From: Paul Cann <Paul.Cann@arun.gov.uk>
Sent: 03 June 2020 14:25
To: Planning.Responses <Planning.Responses@arun.gov.uk>
Cc: Sarah Burrow <Sarah.Burrow@arun.gov.uk>
Subject: RE: Planning Consultation on: Y/39/20/RES

Engineers comments in respect to surface water drainage:

APPLICATION NO: Y/39/20/RES

Description of Works: Approval of reserved matters following outline consent Y/49/17/OUT & Section 73 permission Y/13/19/PL for 45 No. dwellings & associated works. This application may affect the setting of a Listed Building.

PRELIMINARY ENGINEERING
LAYOUT

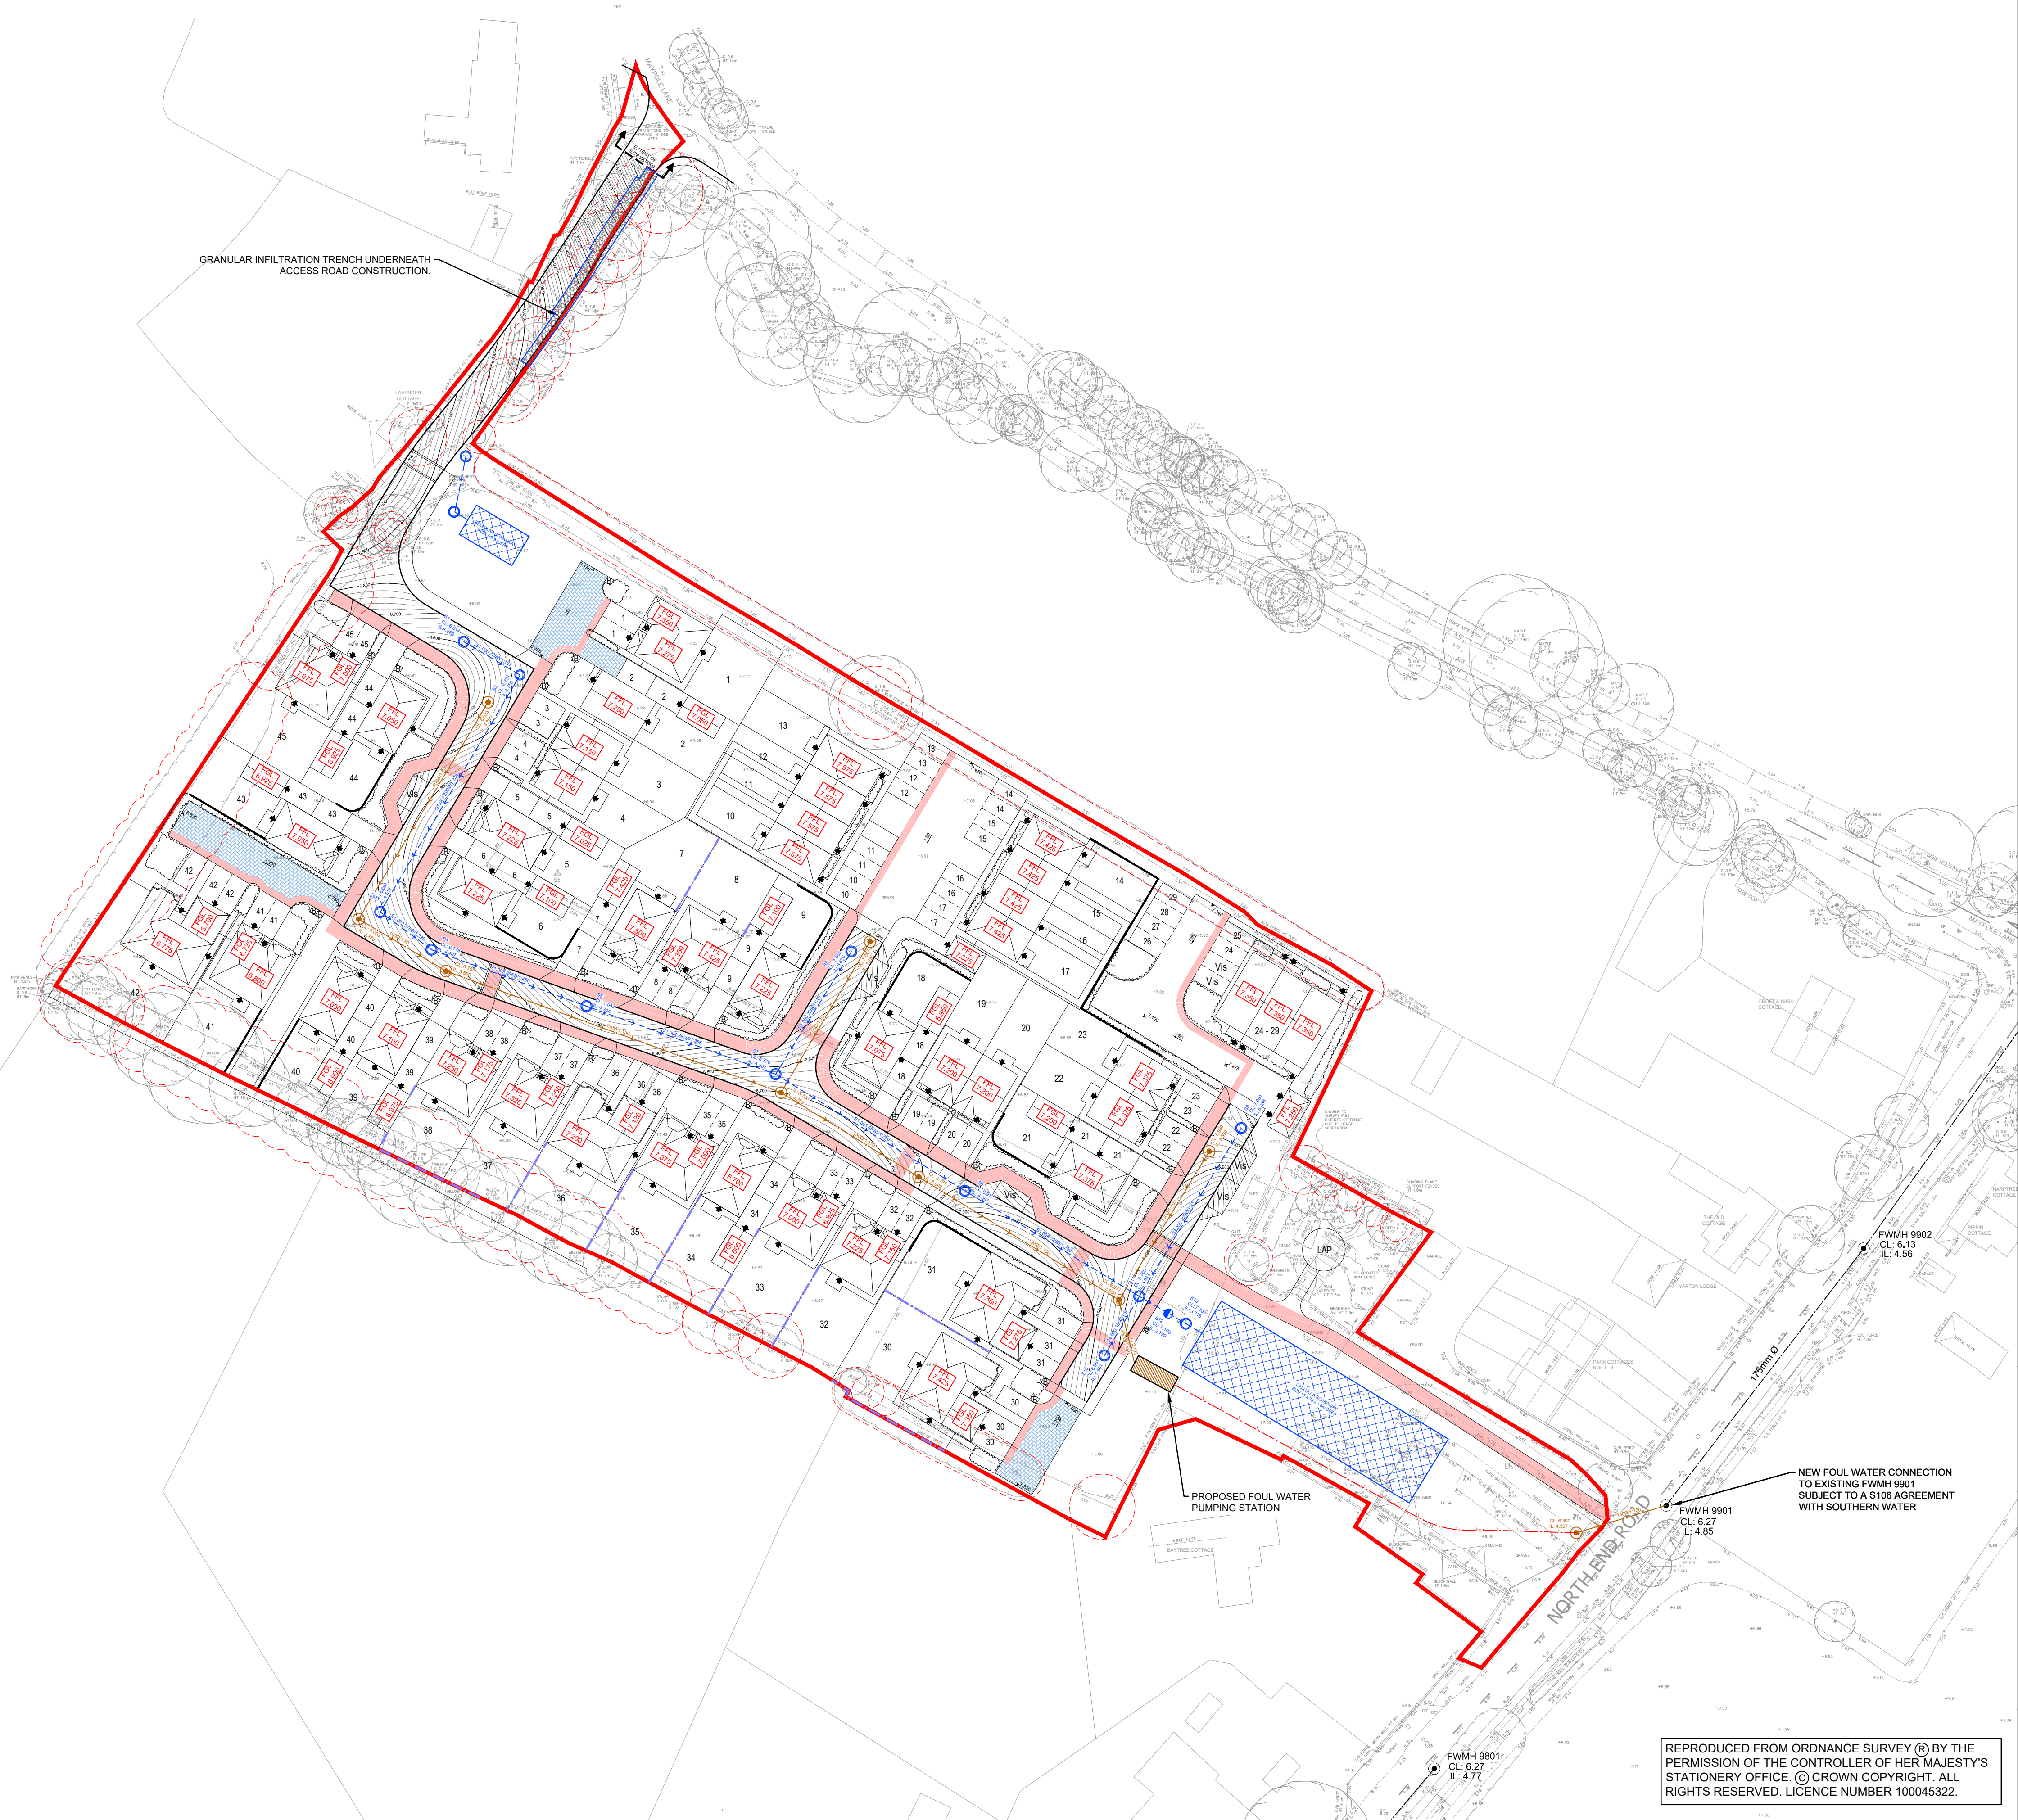
The proposals relies on the discharge of surface into the ground via infiltration. Based upon the ground conditions identified, and discussions with the applicants engineers, it is clear that finding an acceptable drainage solution is going to be a challenge due to the reported poor infiltration rates. Therefore, more discussion and investigations will be required in order to try and find a solution. Therefore, at this time it is not possible to say what form the drainage system will take.
